April 6, 1983

RE: CONDOMINIUM DEVELOPMENT DRAINAGE PLAN

March 30, 1983

DRAINAGE AND GRADING PLAN FOR A CONDOMINIUM DEVELOPMENT FOR ALBUQUERQUE

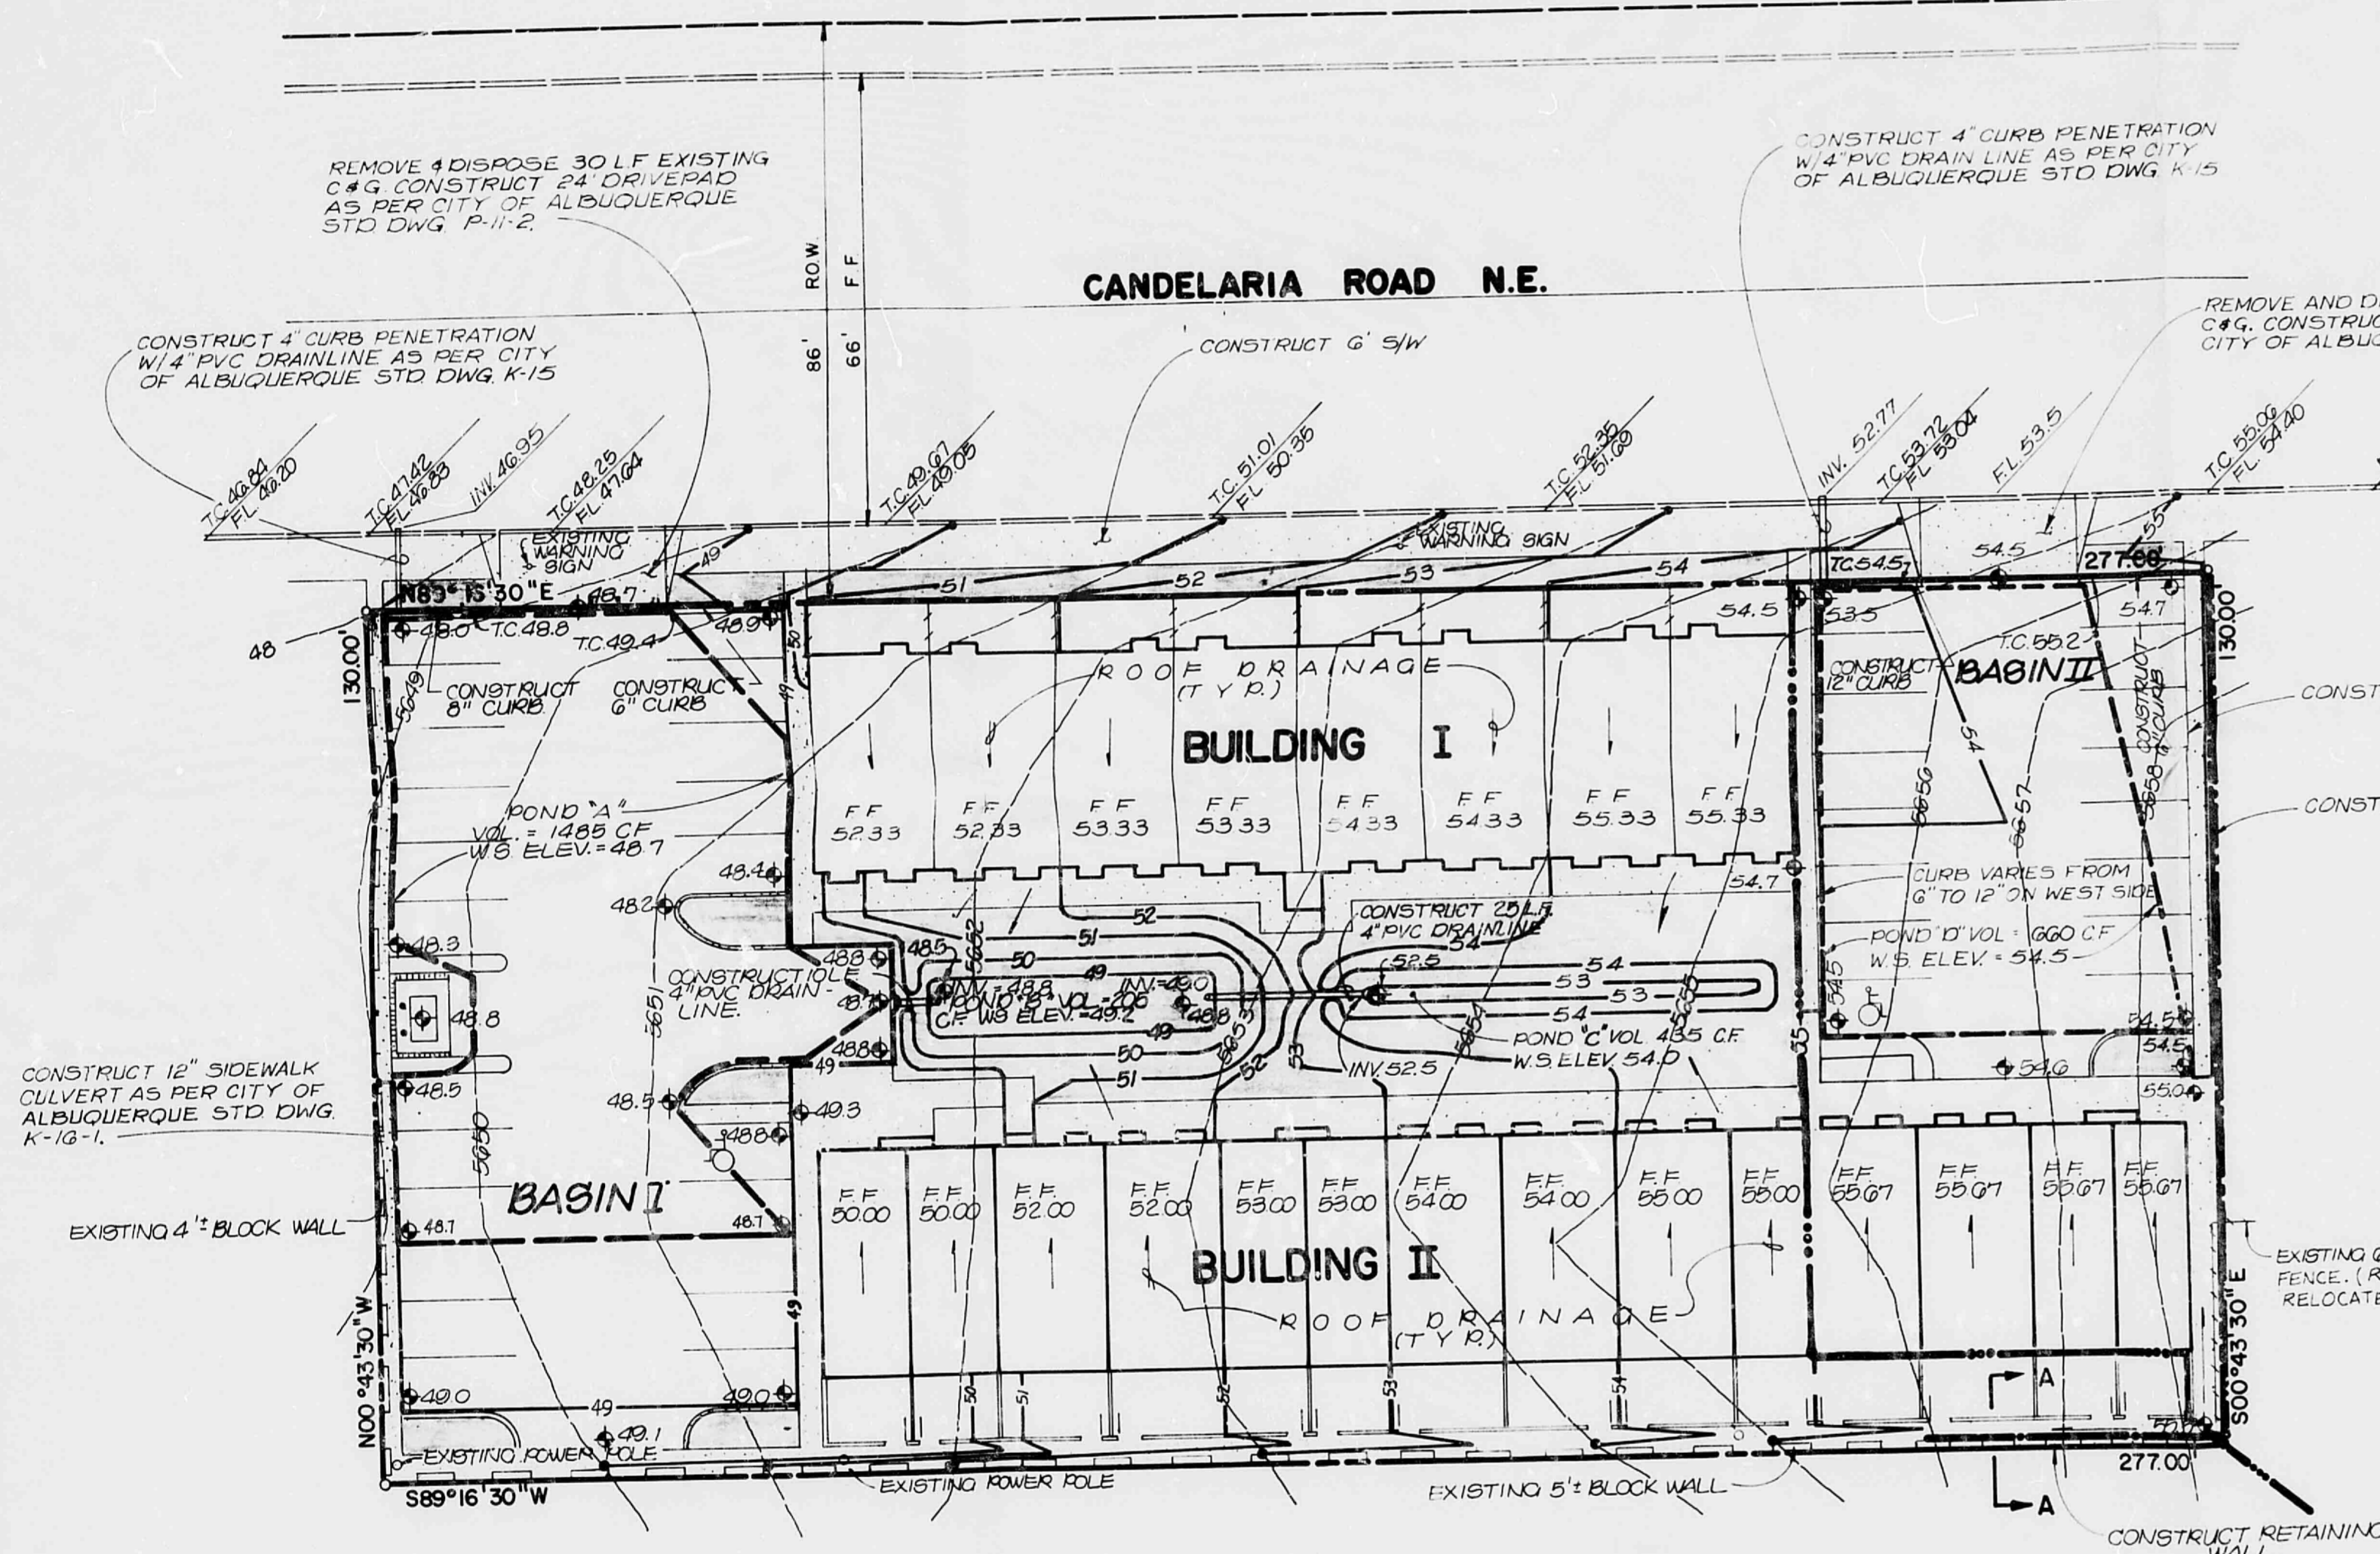
1. Approved copies of "Construction of Private Storm Drain Improvements Within City Right-of-Way" will be required prior to Hydrology sign-off.
2. Please re-date the plans since the concept has changed from the first submittal.
